Highways and Transportation

Application - SE/24/00230/FUL

Location - Bluebell Cemetery Old London Road Badgers Mount Kent TN14 7AE

Proposal - The provision of a new exit road and associated cross over onto Old London Road.

TITLE
 PROPOSED ACCESS ROAD

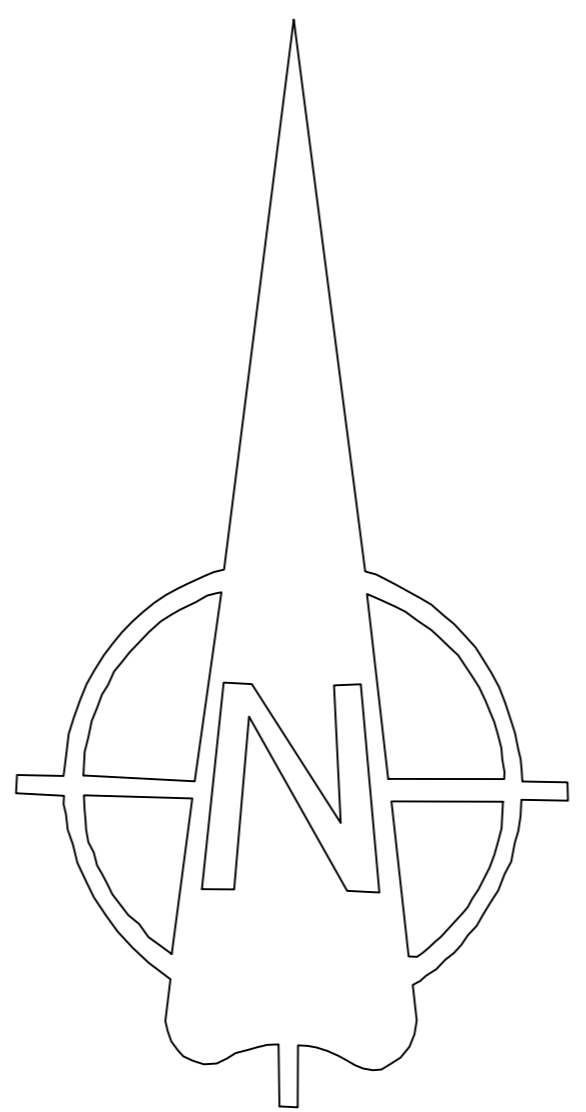
The proposals would result in a new access on Old London Road, which is a classified 'C' road and visibility splays are therefore required. As the access is located within the 40mph speed limit, visibility splays of 2.4m x 104m are required in both directions, with no obstruction over 1.05m above carriageway level within the splays. The applicant should submit a drawing to demonstrate that any land crossed by the splays is within the applicant's control, or that of Kent County Council as the Highway Authority.

The access will require a bound surface for the first 10m from the edge of the highway and the provision of measures to prevent the discharge of surface water onto the highway.

Any gates should open away from the highway and be set back a minimum of 10 metres from the edge of the carriageway.

A site plan has been submitted; however, this only shows the proposed exit road and vehicle crossover. Whilst I understand that the new exit road will only allow visitors to exit the car park, clarification is needed as to whether the existing access will only allow vehicles to enter the site, forming a one way system throughout the site.

I am unable to ascertain whether this proposal would affect the area designated for an overflow car park, which was approved in the original application for the crematorium under SE/19/02317. Clarification is also required as to whether the existing storage units will remain in situ. If these are to remain on the site, they should be shown on the revised plans, to ensure they do not affect the access or parking layout.

I would therefore request a revised site layout plan which shows the full extents of the site, to demonstrate that the parking layout, including the designated overflow car park, will not be affected by these proposals. The revised plan should also demonstrate the one way system throughout the site.
